Application for removal or variation of a condition following grant of
planning permission. Town and Country Planning Act 1990.
Planning (Listed Buildings and Conservation Areas) Act 1990

Number	27
Suffix	
Property name	
Address line 1	Central Drive
Address line 2	
Address line 3	
Town/city	Middleton-On-Sea
Postcode	PO22 7TT
Description of site location must be completed if postcode is not known:	
Easting (x)	498120
Northing (y)	100004
Description

Replacement dwelling	
Reference number	
M/25/19/PL	
Date of decision (date must be pre-application submission)	11/09/2019
Please state the condition number(s) to which this application relates	
Condition number(s)	
2 & 4

To regularise amendments to the approved drawings, by amending condition 2 and the removal of condition 4, as requested by Arun District Council

PROJECT	27 Central Drive - Elmer Beach	DATE	16/09/18
TITLE	Proposed South Elevation	DRG NO	IBA/507/05
SCALE	1 : 50	REVISIONS	B

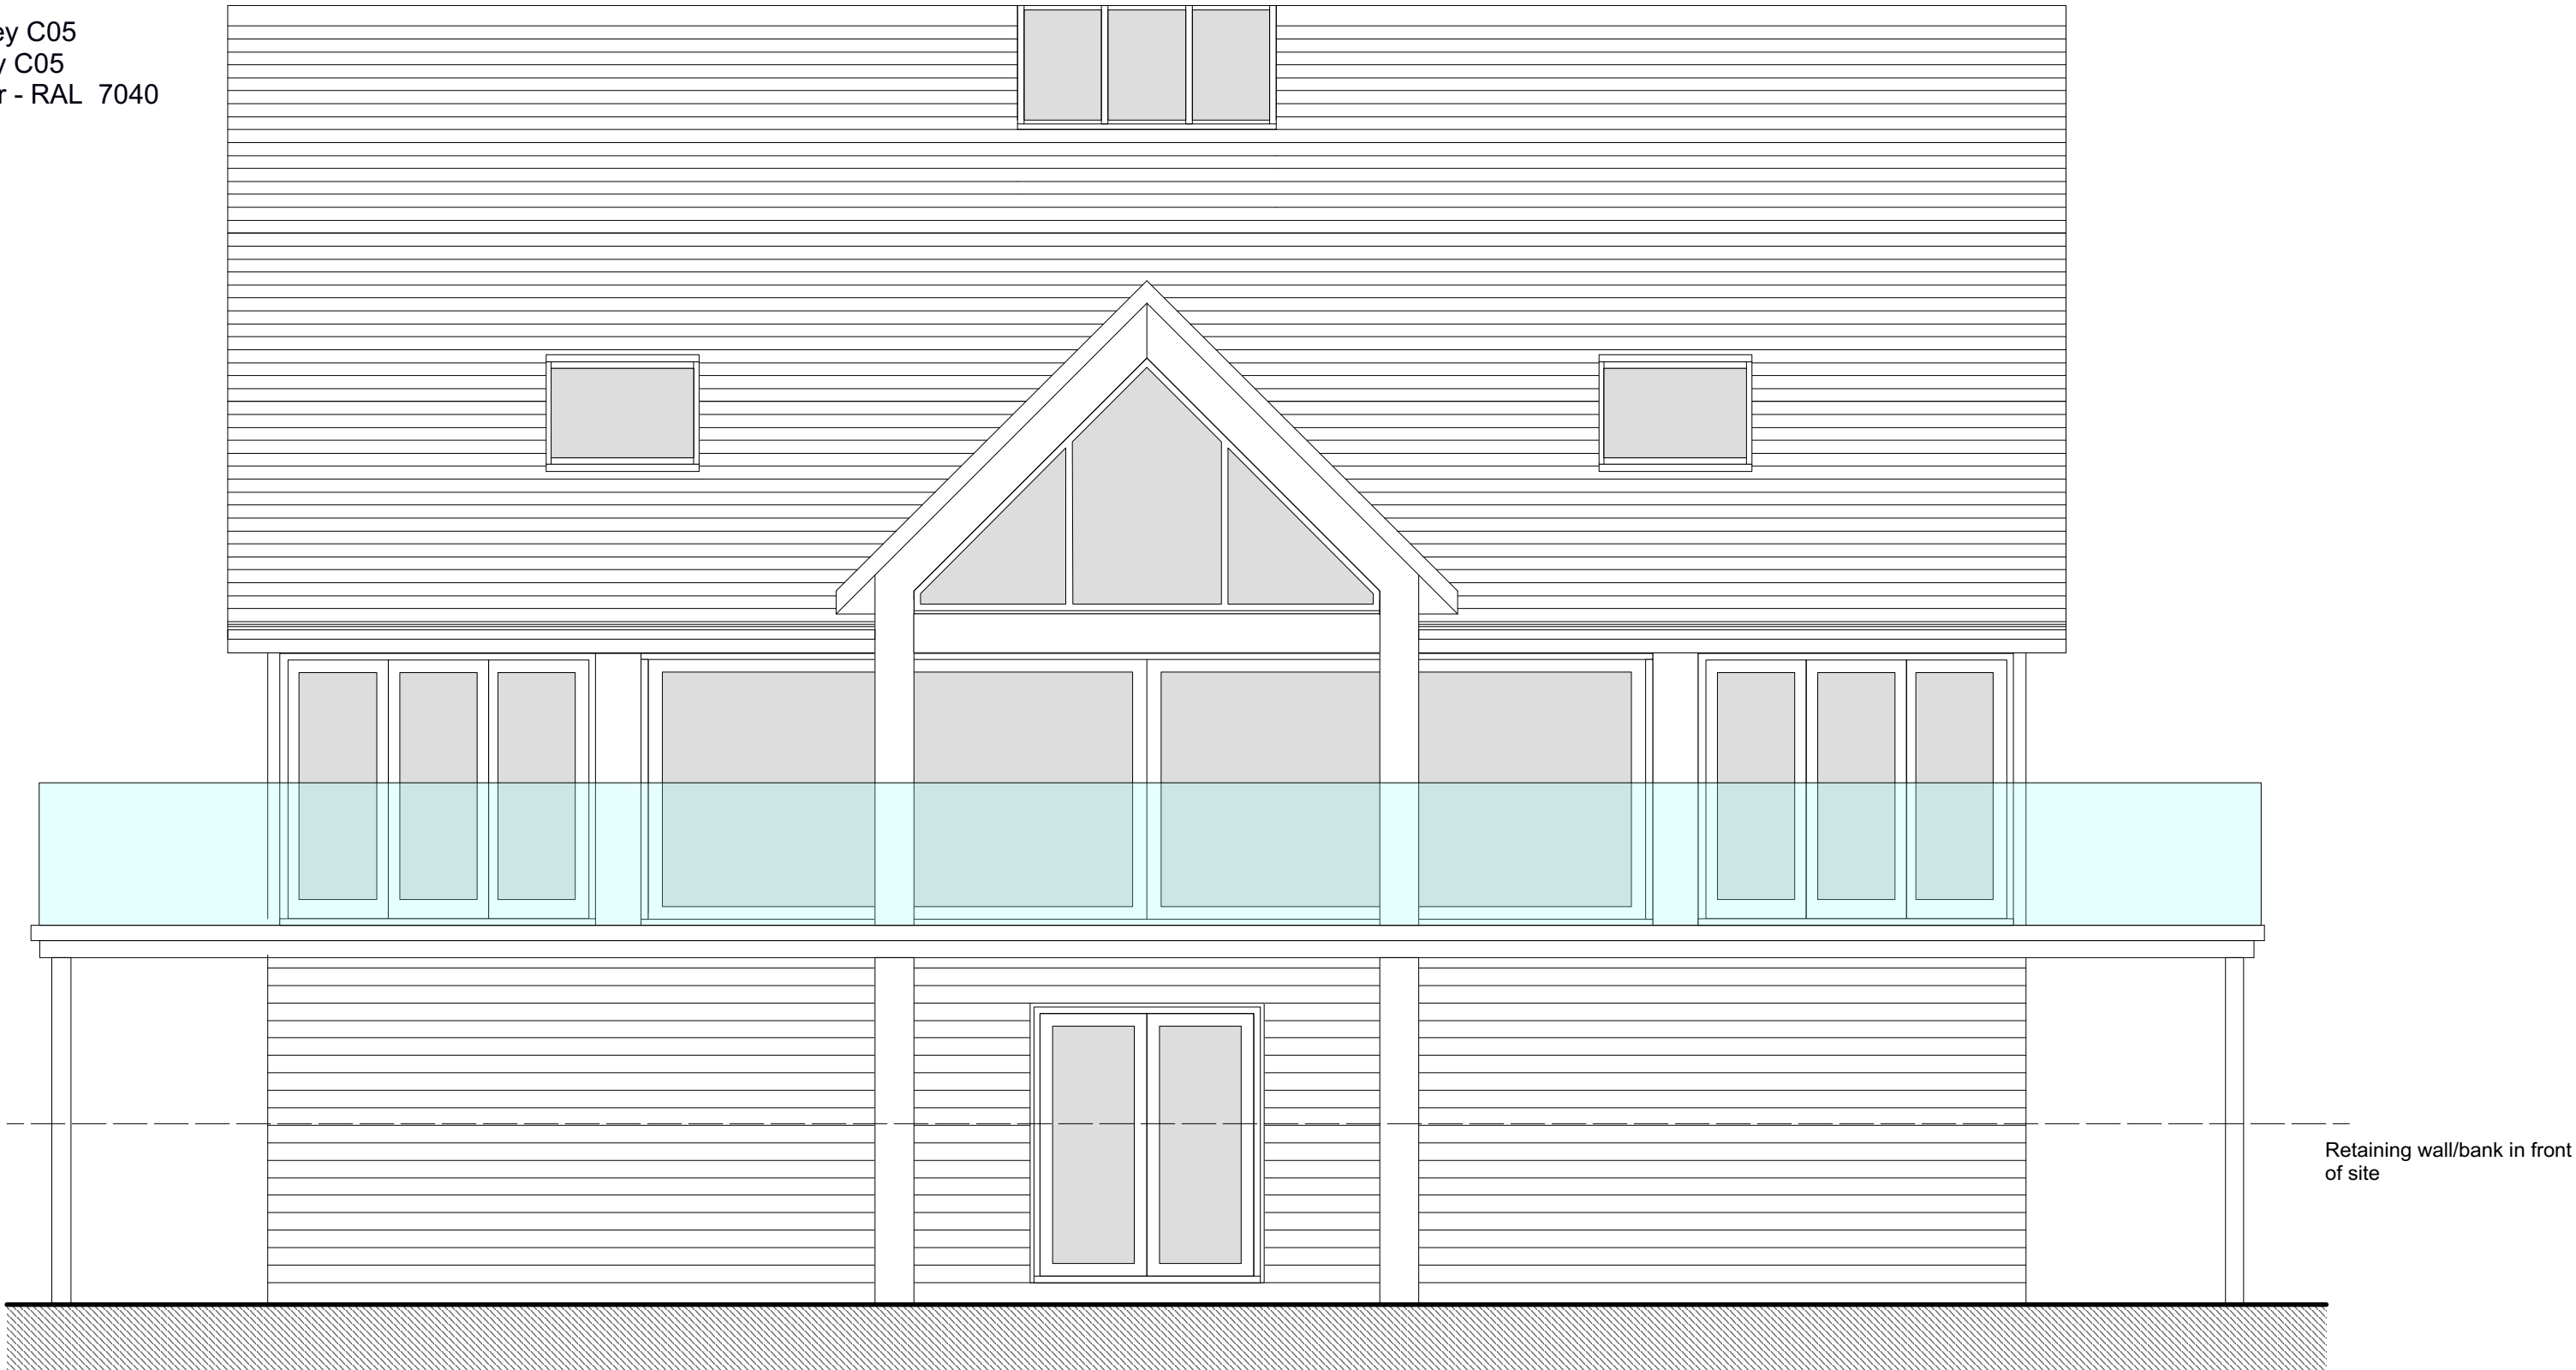
Removal of the street scene elevation from the list of approved drawings to which the application relates;
Amend the approved first floor elevational plan to show the privacy screen in the correct location and at a height of 1.8m (Note: the first floor plan and the east elevation do not currently coincide);
Amend all relevant plans to remove the link extension between the new dwelling house & No 25 Central Drive;
Changes to some windows/rooflights that the client no longer wants and pick up some minor changes to the approved drawings;
Amend the relevant plans to include the proposed materials & finishes for the development.

Condition 4 materials now included on the above drawings, so not required.
